KITITAS COUNTY

MEMORANDUM

TO: All Staff
FROM: Public Works Plan Review Team
DATE: September 24, 2025
SUBJECT: SE-25-00014 Shamkhi

HOLIDAY HILL PRELIMINARY DESIGN
MUNIR SHAMKHI
PRELIMINARY GRADING PLAN

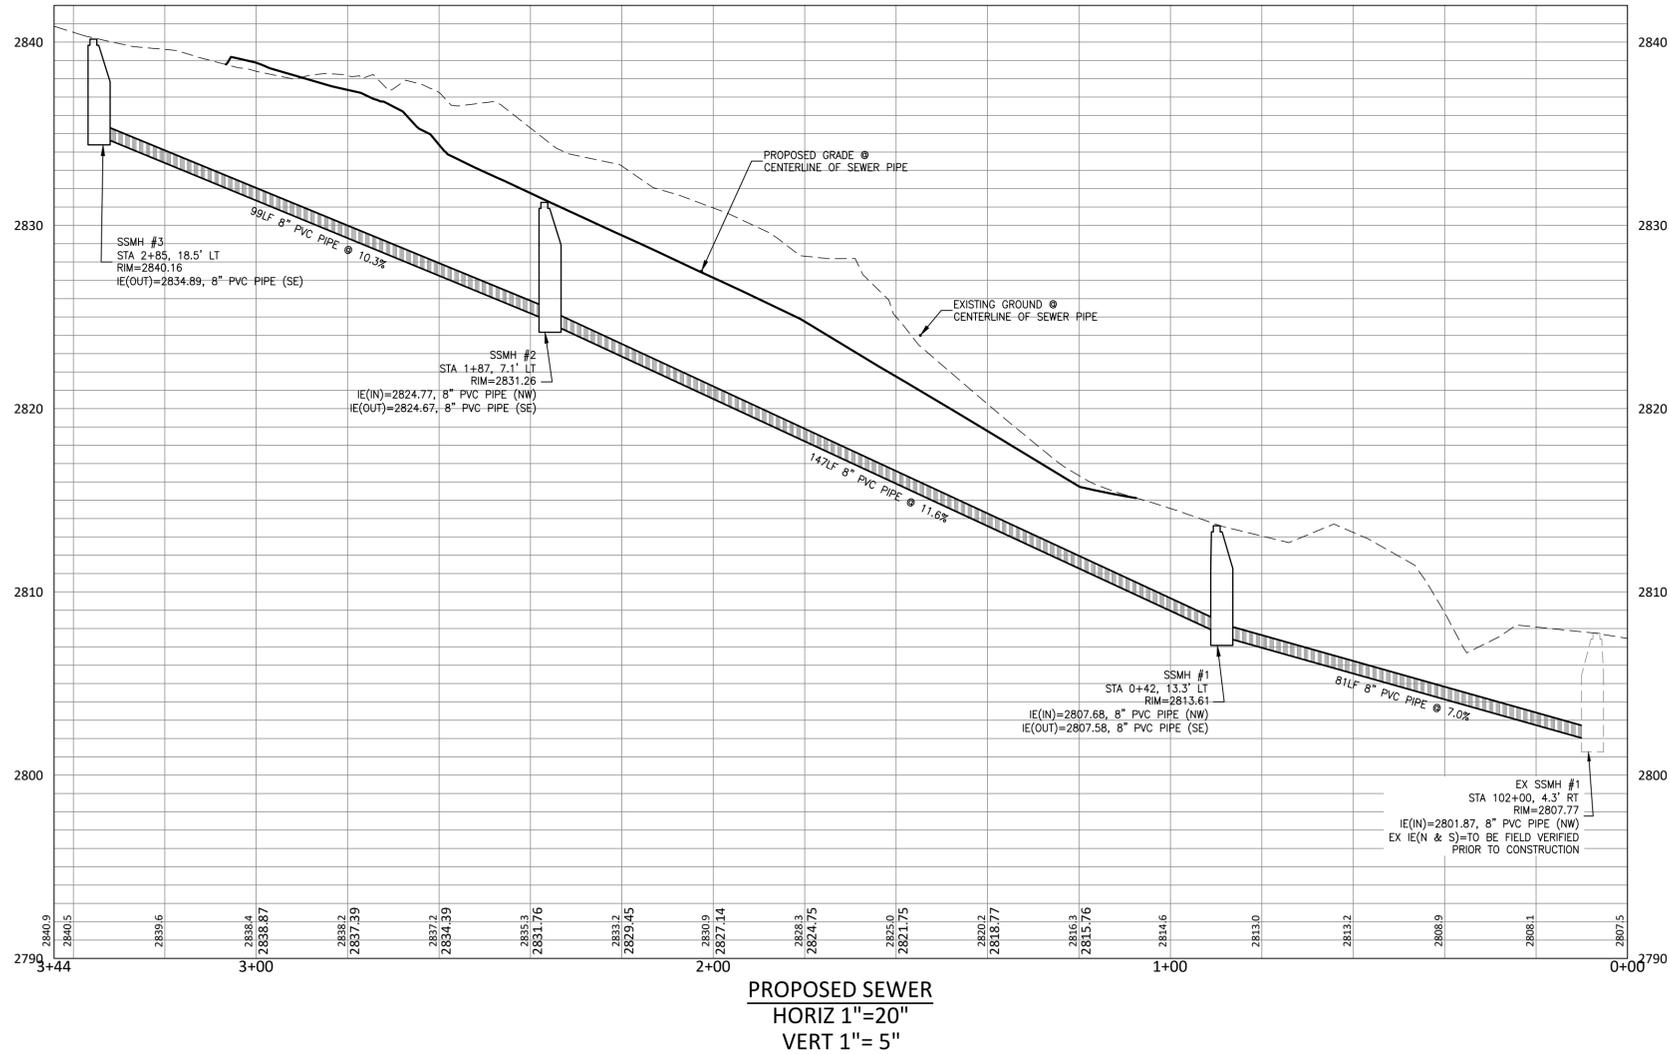
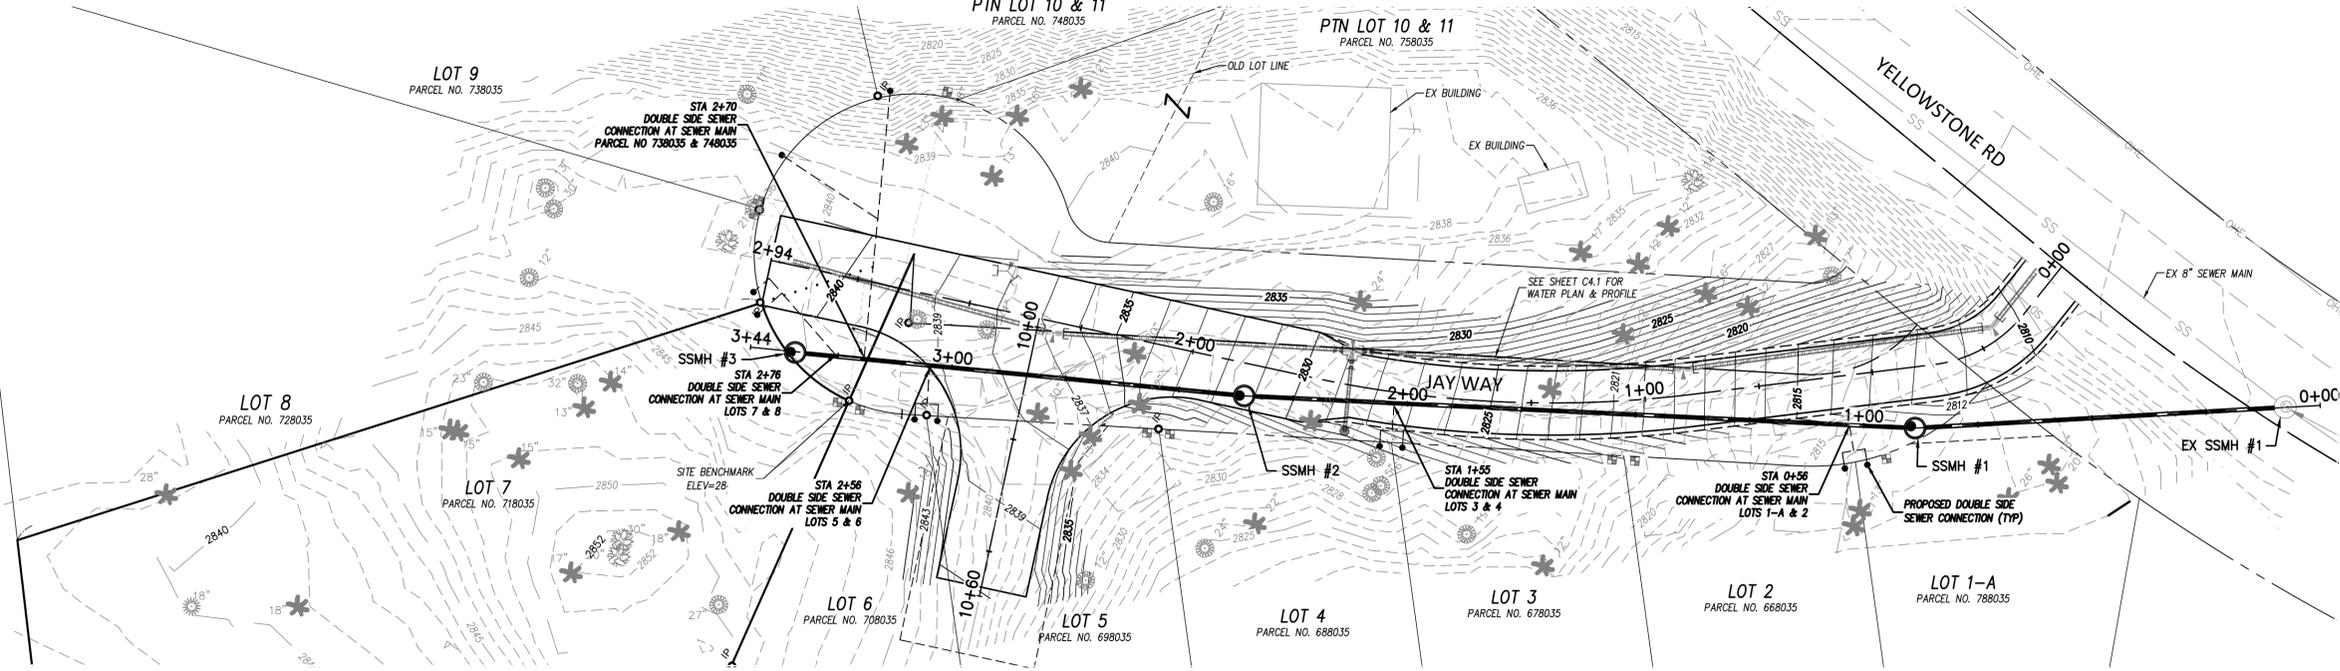
ENGINEERING	<p>A grading permit application has been submitted for this project (GP-24-00017) and comments have been sent to the applicant (as of the date of this comment 9/15/2025). Additionally, a stormwater report will be required if the grading is over 500 cubic yards.</p> <p>Per County Code 12.04.08.040 "Side slopes shall be constructed no steeper than two to one on both fill and cut slopes. Steeper slopes may be approved by the County Engineer upon review of a geotechnical investigation...". Please provide justification that a 1.5:1 (H:V) side slope will be stable. (CBP)</p>
SURVEY	<p>There are no survey comments regarding this application (JT).</p>
TRANSPORTATION CONCURRENCY	<p>No transportation concurrency requirement for this project. (KAH)</p>
FLOOD	<p>No comments. (SC)</p>

PTN LOT 10 & 11
PARCEL NO. 748035

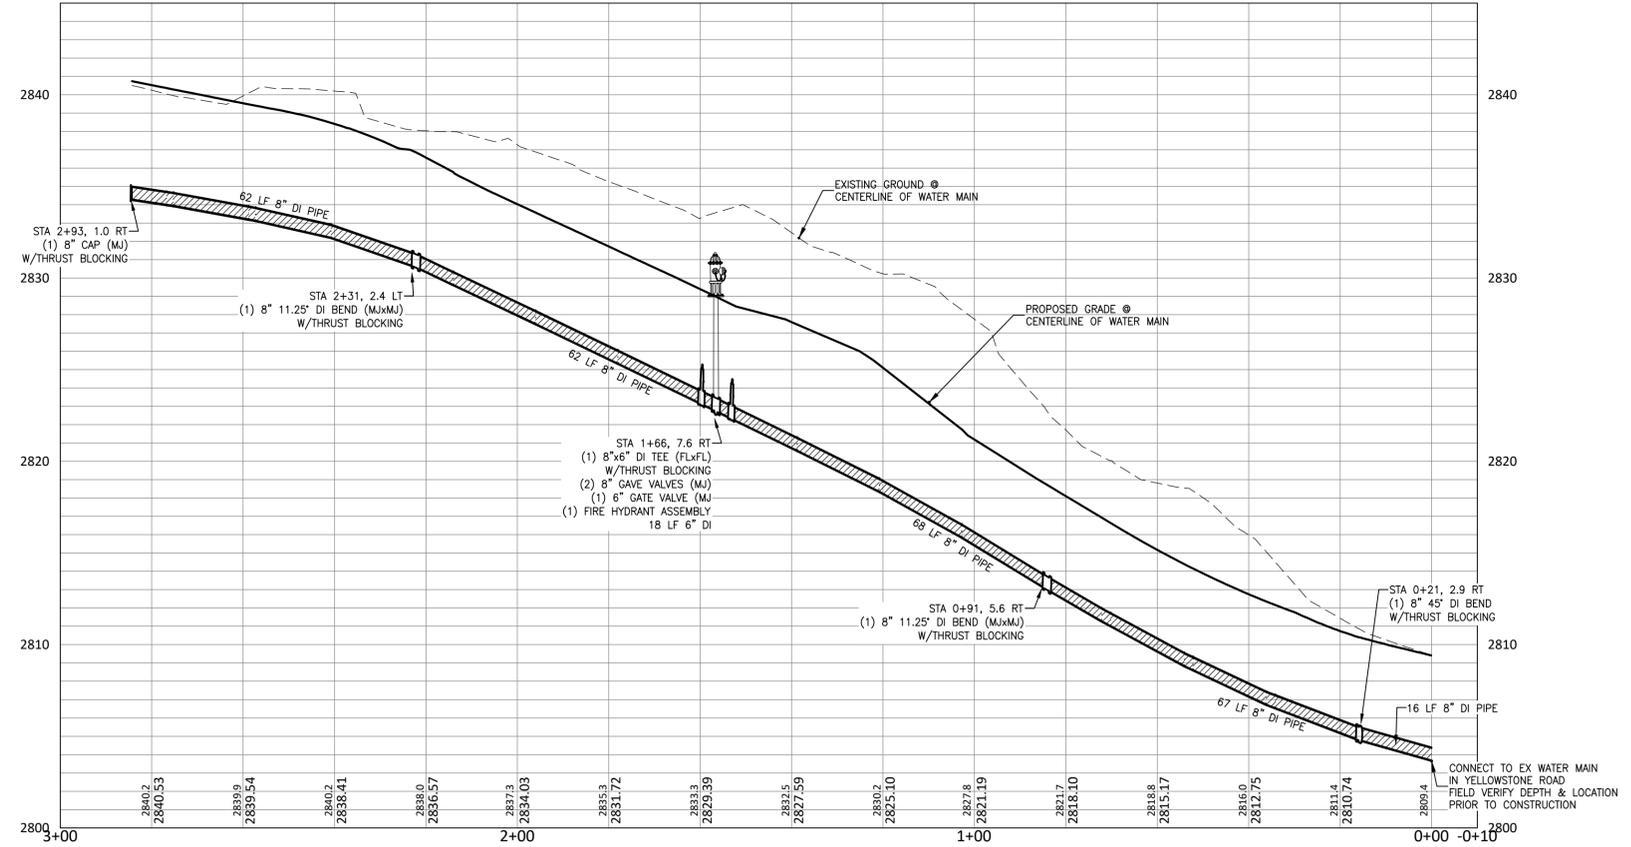
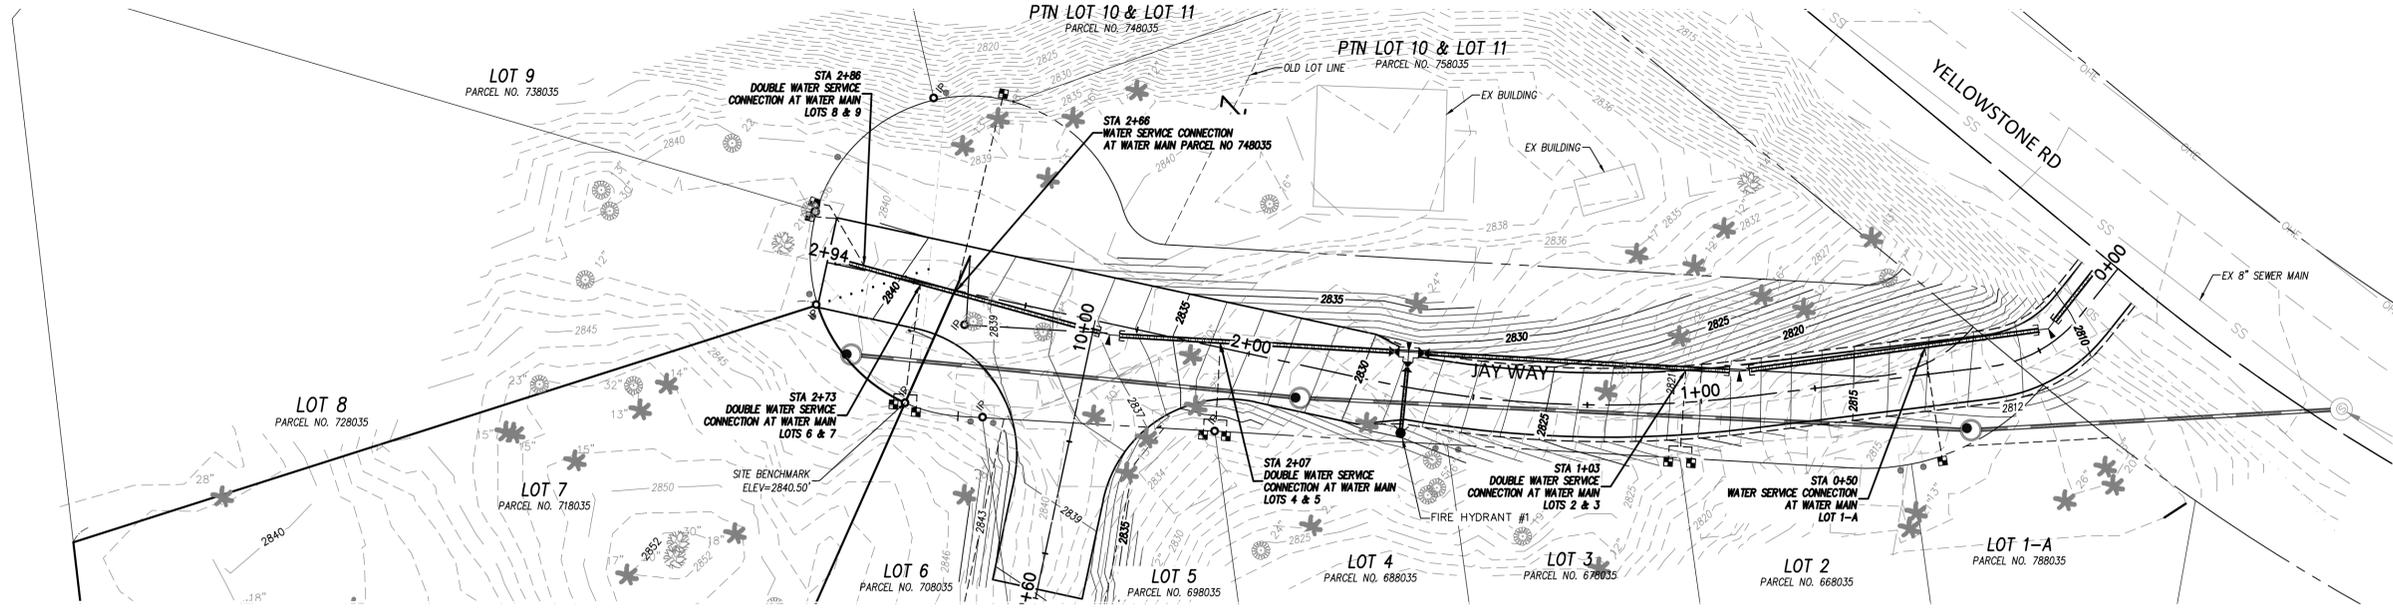
ACCESS	<p>It appears that PTN Lots 10 & 11 are part of this plat and utilize Jay Way to access said lots. If so, access will need to be maintained as part of this project. (CBP)</p> <p>A Private Road Access Application has been submitted for this project, and construction of the Apron for Jay Way(AC-24-00072)</p> <p>An Access Application has been submitted for a single-family residence (AA-24-00084) at 110 Jay Way</p> <ol style="list-style-type: none"> 1. An approved access permit shall be required from the Kittitas County Department of Public Works prior to creating any new driveway access or altering an existing access. 2. Maintenance of driveway approaches shall be the responsibility of the owner whose property they serve. The County will not maintain accesses. <p>In addition to the above-mentioned conditions, all applicable Kittitas County Road Standards apply to this proposal. Access is not guaranteed to any existing or created parcel on this application. (RC)</p>
